8 August 2013

### **SSD 13\_5878 - SICEEP Haymarket Stage 1 DA Response to Submissions**

## SSD 5878 Haymarket Stage 1 SSDA - City of Sydney comments on Response to Submissions Report

Figure 4.17. Precedent for car parks with super graphics

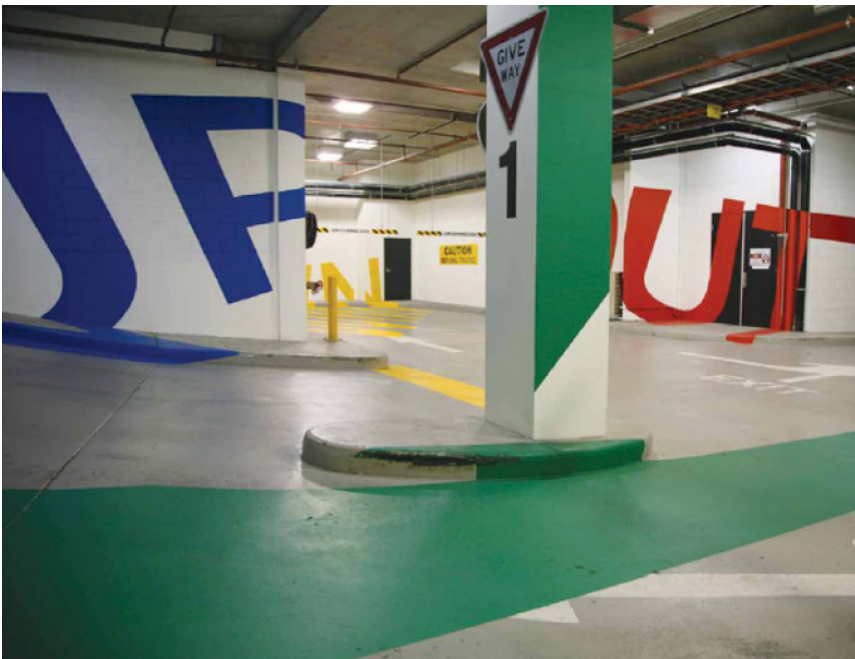
Issue	Applicant Response	Issue Addressed?	City's Contention
	glazed retail shopfronts or residential lobbies.		
6. Skin exposed car parking with floor space or, where not possible,	<p>Skinning of exposed car parking will be provided by decorative architectural features.</p> <p>Catenary lighting is proposed along Dickson's Lane to maintain ground plane focus and create ambience.</p>	No	The exposed car parking should be skinned by land uses, such as affordable housing product at lower levels.

Figure 3.3. The Haymarket massing strategy

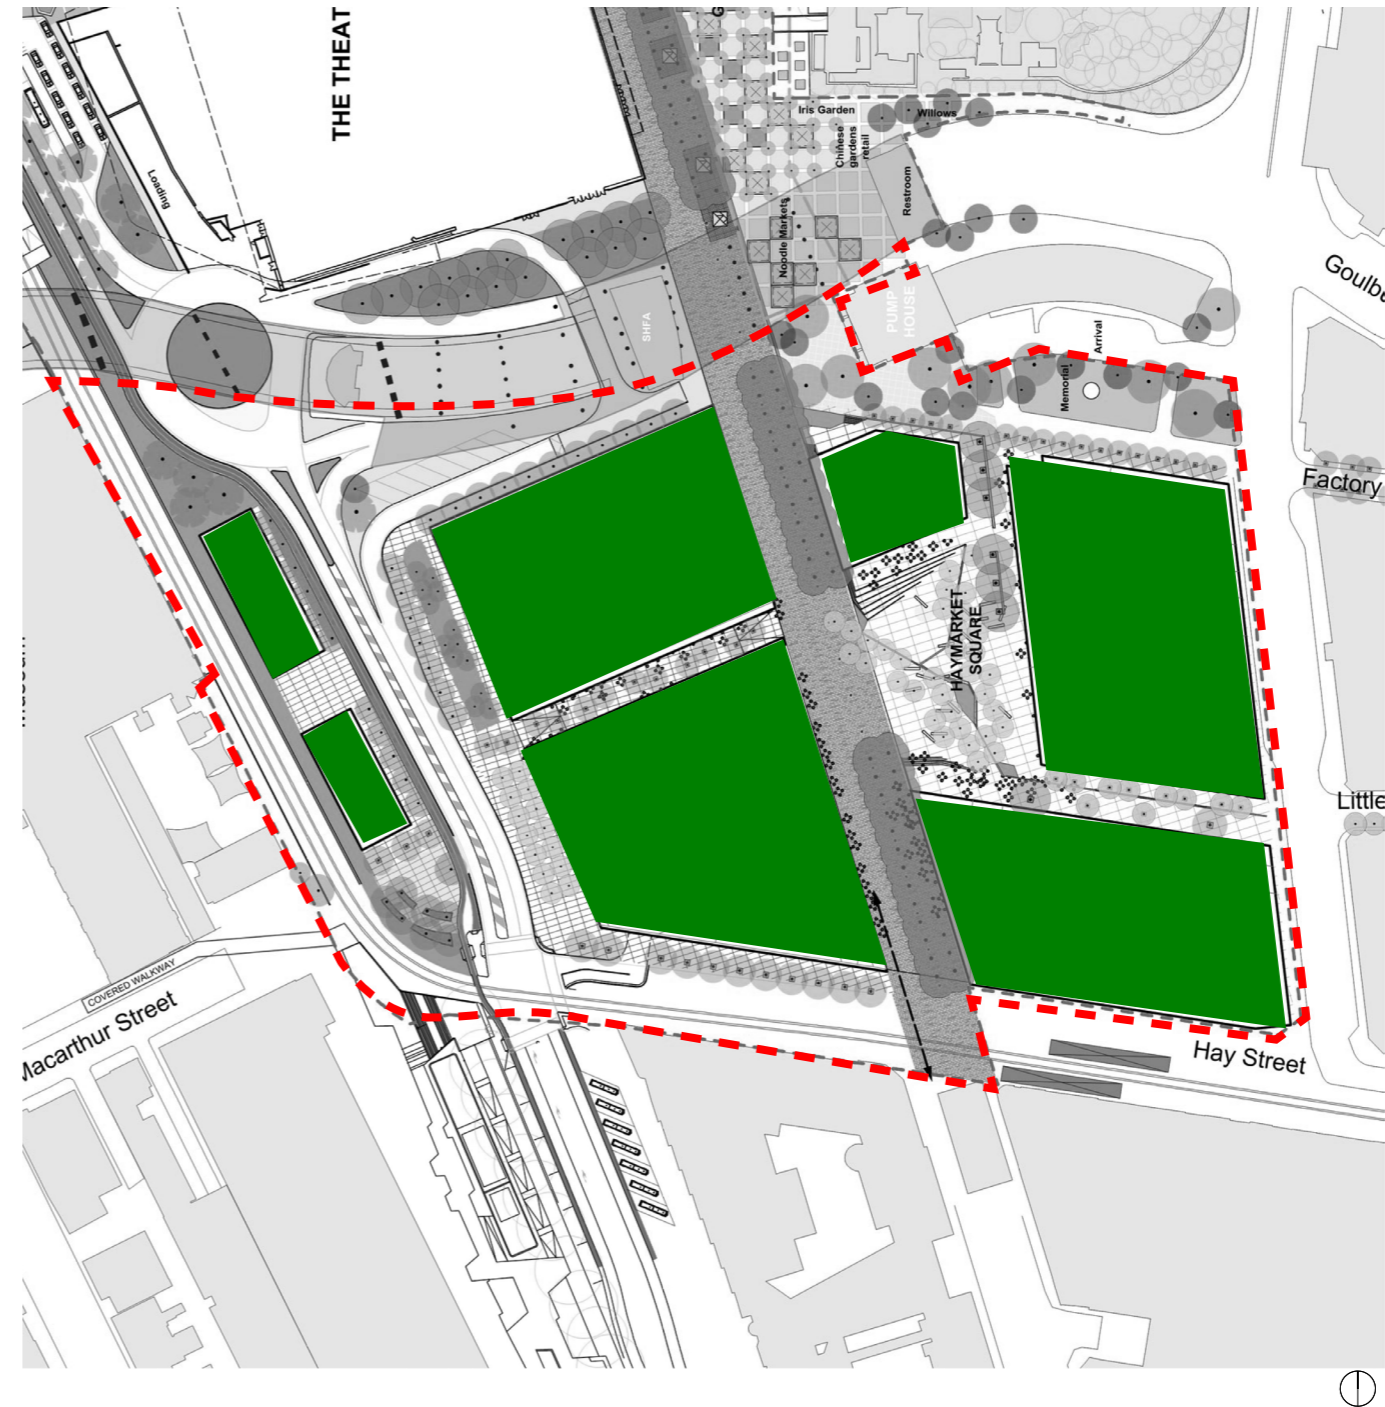
Issue	Applicant Response	Issue Addressed?	City's Contention
1a. Reduce number of tall towers from 4 to 3 to reduce tower crowding, amenity impacts and allow for the Macarthur Street alignment.	<p>The proposal is a result of rigorous master planning. The number of tower is driven by commercial objectives, demand and the ground plane layout for street pattern and open space.</p> <p>Four towers are preferred over three towers of larger bulk and/or height.</p> <p>Tower overcrowding is mitigated by variation in the height of the towers at 25 storeys and 40 storeys.</p>	No	<p>The loss of the ability to retain the existing street pattern of Macarthur Street is the most significant issue for the City.</p> <p>The four towers is aided by the decision not to comply with the minimum setbacks in the urban design guidelines. The City has demonstrated how the proposed towers can be amended to retain the Macarthur Street alignment, with lost floorspace reallocated to the podium edges or via increased height for the three towers.</p>

1b. Setback towers at least 5m from podium edges	<p>The design intent of the chosen composition is to introduce street edge buildings to achieve diversity on the elevations.</p> <p>By locating towers visible from the street level provides a sense of place for residents and ease of wayfinding for visitors. The proposal allows for a continuous reading of the street wall rather than a podium and tower creating a physical separation which allows towers to appear to be floating above the street wall.</p> <p>By locating development around the site's perimeter, the separation between buildings has been maximised.</p> <p>Articulation along the street wall provides</p>	No	<p>Towers should be setback at least 5m from the podium edges as illustrated in the INSW urban design guidelines to provide appropriate street scale, reduce wind downdrafts, reduce the overbearing and sense of enclosure of towers to pedestrians and reflect the desired building character of the Sydney Development Control Plan 2012.</p> <p>The City encourages the proposed articulation along the street wall. However, that articulation should be strong within a podium form and towers should be setback from the edge.</p> <p>Building separation shown in the envelope plans is insufficient and would be improved with the reduction from four towers to three.</p>
